March 4, 2019

Re: CAO 15-001, SEP 15-001, VAR 18-002
Containment Wall Requirement

SOUTH ELEVATION

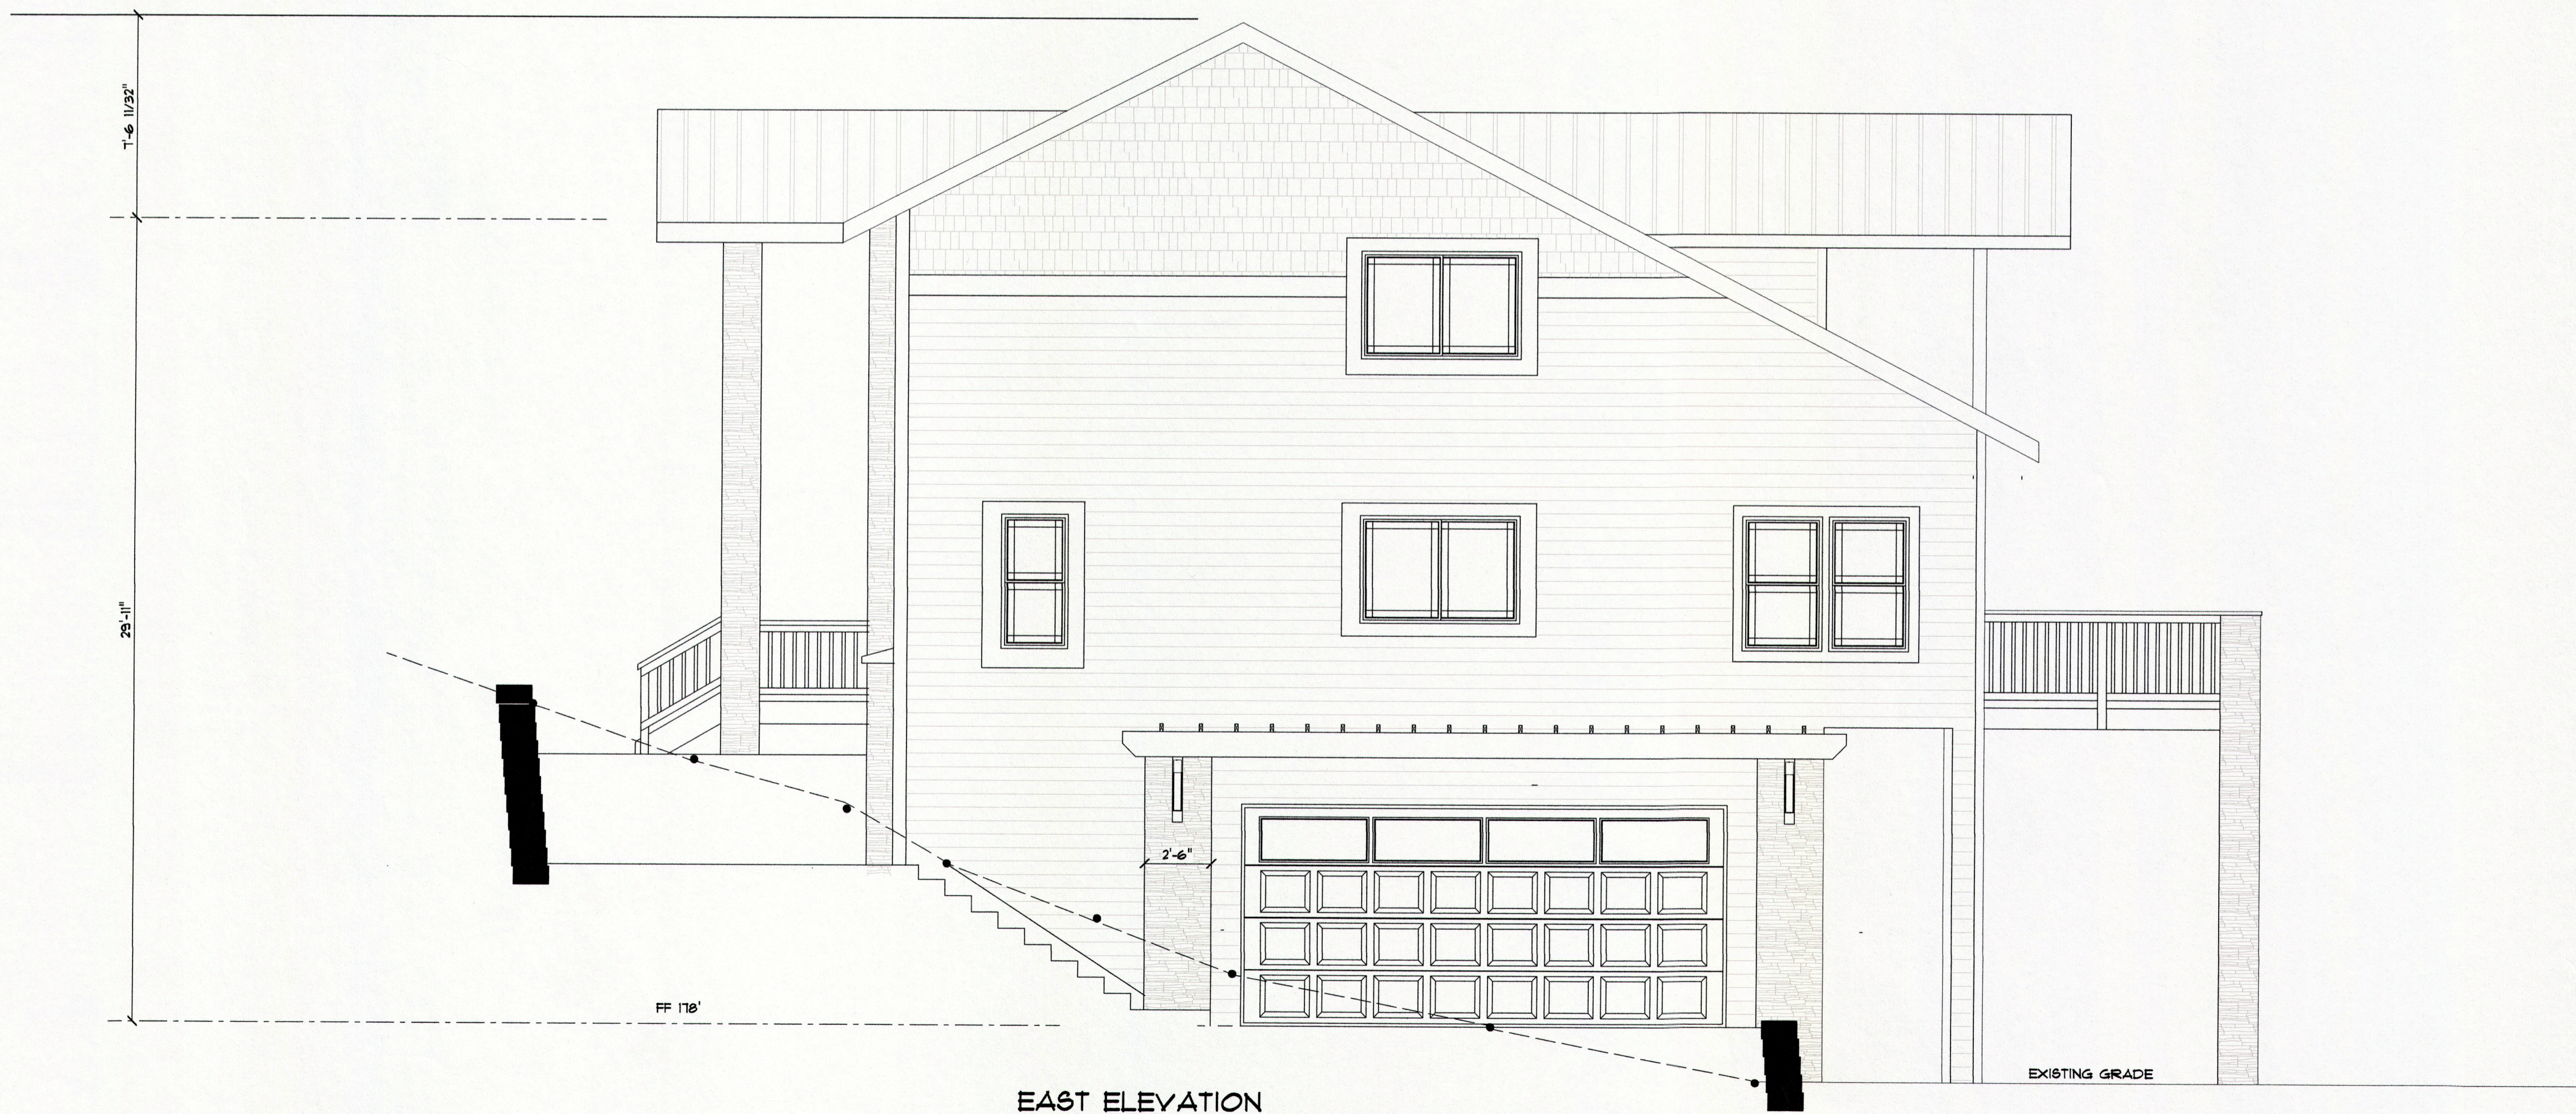
The plan submitted by Treehouse subsequent to the hearing shows a catchment wall built into the southeast wall of the residence facing the slope to the southeast. GEO had originally proposed in its letter of July 30, 2015, a catchment wall for the southeast wall of the residence, but this idea was subsequently abandoned. Rather, GEO recommended that “the wall alignment should run south of the residence **and continue around the southwest corner a distance of another approximately 20 feet.**” [Emphasis added.] Using the southeast wall of the residence as a catchment wall simply does not comply with this requirement. The proposed residence remains exposed to landslides from the steep slopes to the southwest and south of the residence. Aside from the topographic map, one can readily see from a visit to the site that the slopes to the southwest and south of the residence are far steeper, more precipitous, and much higher than the slope to the southeast.

Based on the foregoing, it is submitted that the current plan for the proposed residence does not comply with the safety criterion specified in 19.07.030(B)(3)(e). This is simply one of many reasons why the Treehouse application should not be supported by the City.

Topography of the Lot (Yellow Outline) and Surrounding Areas

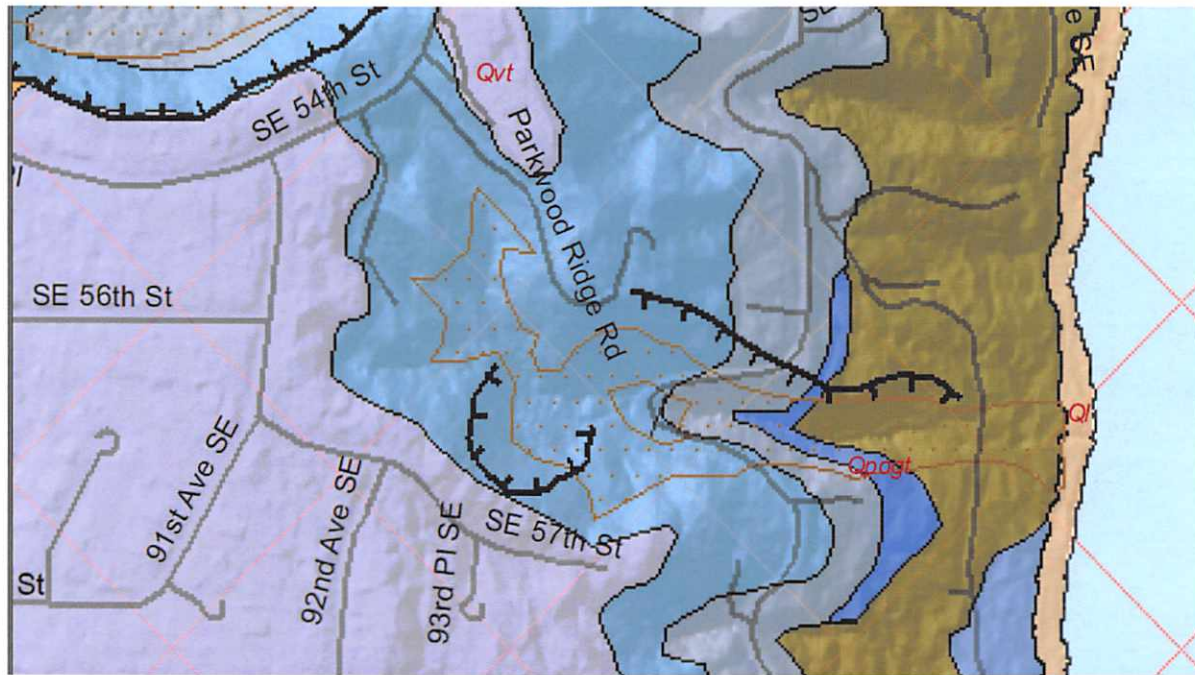
The reference to the "steep slope south and southwest of the proposed residence" is clearly understandable as the steepest slopes are in those directions. This can be seen by the topographic map of the area found in the GEO letter of February 4, 2016, at page 3 and shown below:

The black line superimposed on the map is the approximate location of the southeast wall of the proposed residence. The slope to the southeast of the residence is relatively mild compared to the very steep slopes south and southwest of the residence.
